Subject: FW: *EXTERNAL: BN/18/20/PL, Former Brooks Nursery

Please upload the below to the above application; an existing kiosk and fence

There is a new requirement from my manager, an elevation of the proposal site showing what will be above the ground.

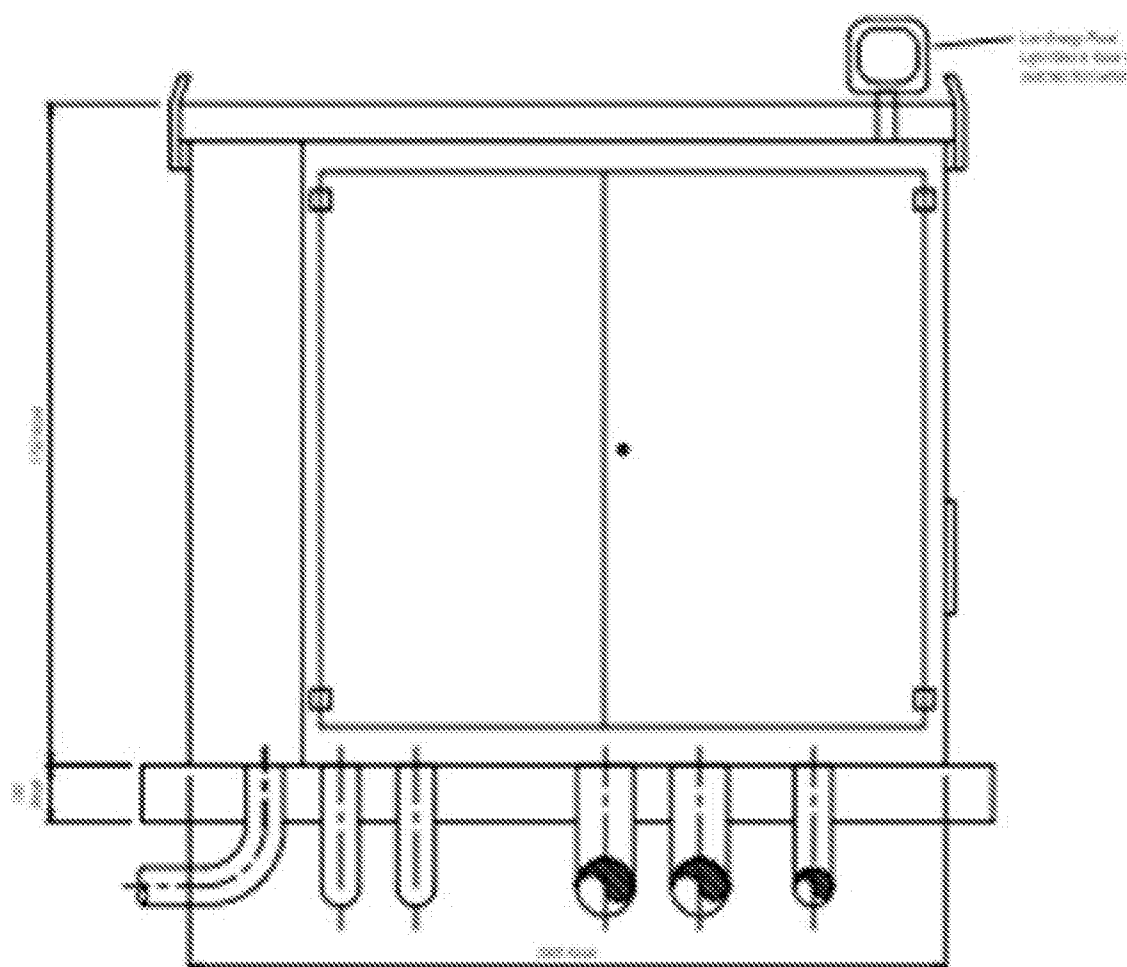
Not really – that is only one elevation. Ask them for the others but add the one elevation we have to the presentation. Also amend the report update to make it clear it is the existing fence not a new one.

As discussed, the only item above ground (same as existing) is a kiosk, however the new one is much smaller;. approx. 1.75m high x 0.75m deep x 2.0m wide see below extract

The exiting fencing around the "underground" chambers will remain .
